**Consultation Response from KC,
Trees****Moorgate Farm, Moor Lane, Netherthong, Holmfirth, HD9 3UP****Construction of padel court****Date Responded: 12/02/2026****Responding Officer: Hazel Irving****Responding Ref: 66/92/g2**

Project:	Moorgate Farm, Moor Lane, Holmfirth HD9 3UP
Drawn by:	Jack Delaney
Date:	17th September 2025
Scale:	1:200 @ A1
Drawing Number:	WC-416.1a.4

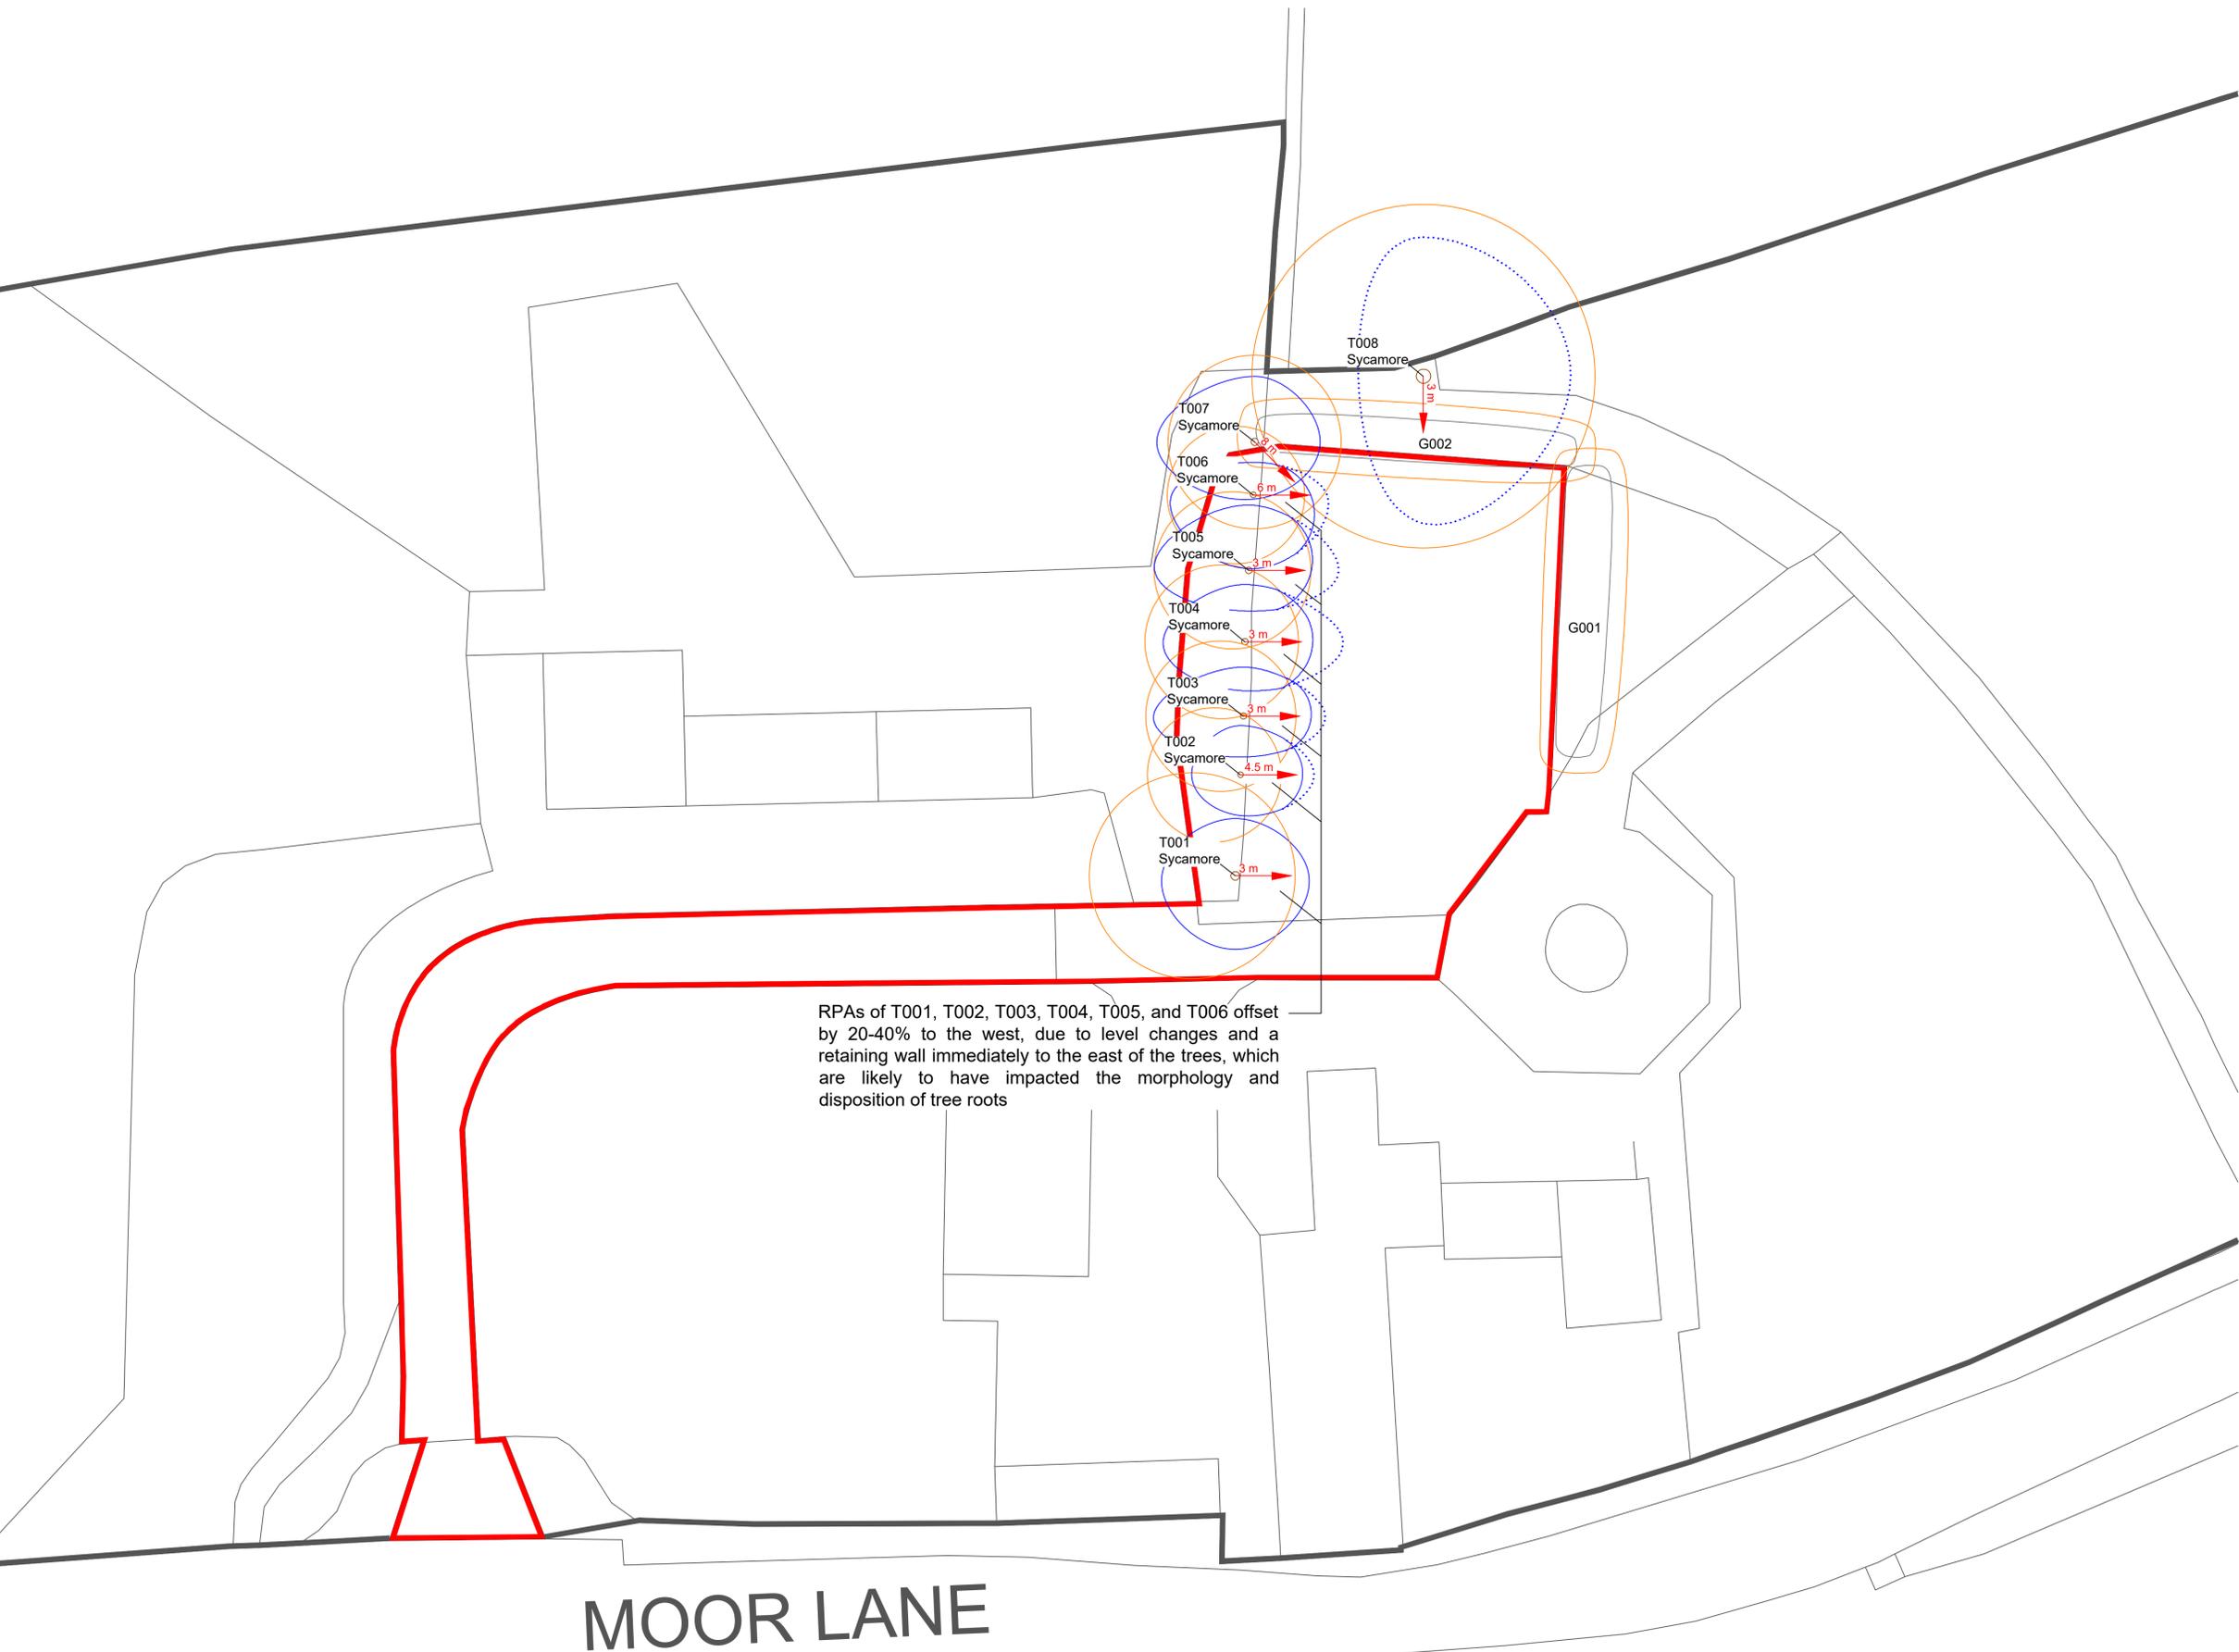
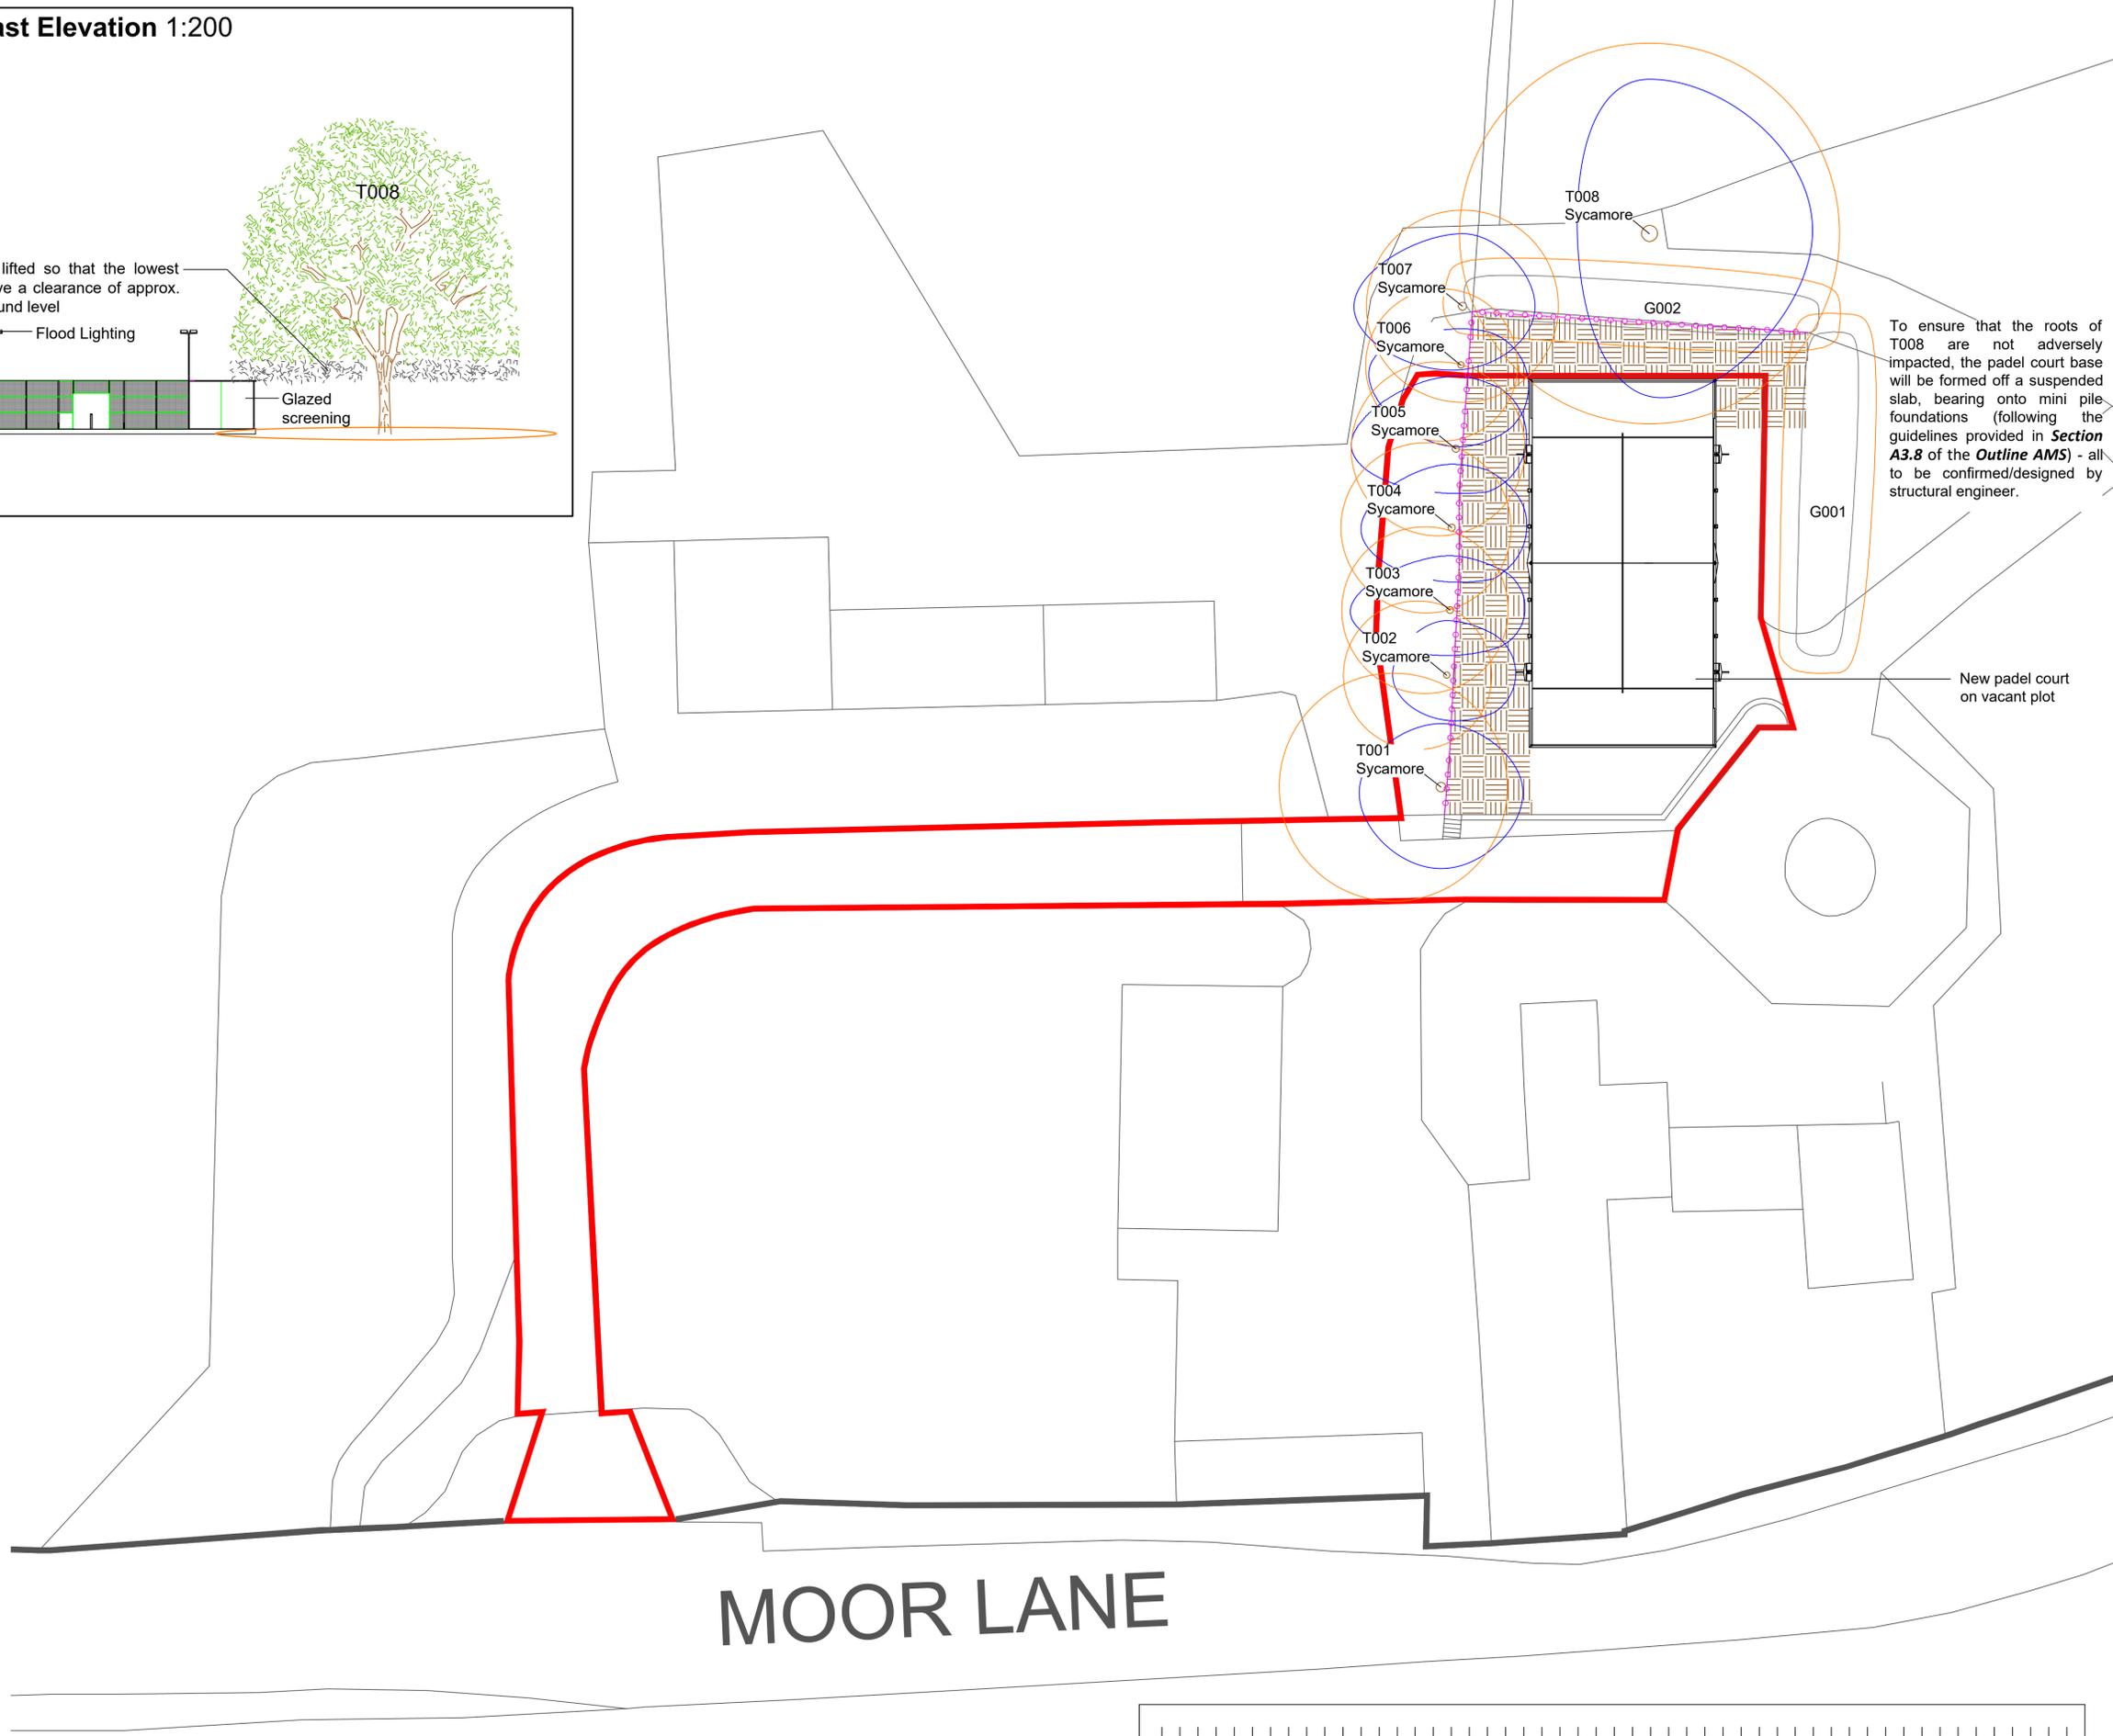
The crowns of T002, T003, T004, T005, T006, and T008 all overhang the proposed location of the padel court. As such, the following facilitation pruning work will need to be carried out to these trees prior to development works commencing:

- Branches extending east from T002 should be reduced by approximately 1 m
- Branches extending east from T003 should be reduced by approximately 1 m
- Branches extending east from T004 should be reduced by approximately 2 m
- Branches extending east from T005 should be reduced by approximately 2 m
- Branches extending east from T006 should be reduced by approximately 1 m
- The southern lower crown of T008 should be lifted **from the branch tips, to allow 5m ground clearance** over the proposed padel court.

The AiA shows that the RPA of T8 would be incurred by the proposals, however the RPAs of T1-T7 have been offset 20-40% to the West due a ground level change and retaining wall immediately East of the trees.

The padel court base will be constructed using a suspended slabs on mini-piles to minimise disturbance to the roots of protected trees.

There are no objections to the proposals from an arboricultural perspective subject to the approval of a submitted Arboricultural Method Statement. Please see AMS Condition below:

Development shall not commence until an Arboricultural Method Statement, has been submitted to, and approved in writing by the Local Planning Authority. The method statement shall include details on how the demolition and construction work will be undertaken to minimise damage to the retained trees. Thereafter, the development shall be carried out in complete accordance with the Arboricultural Method Statement.
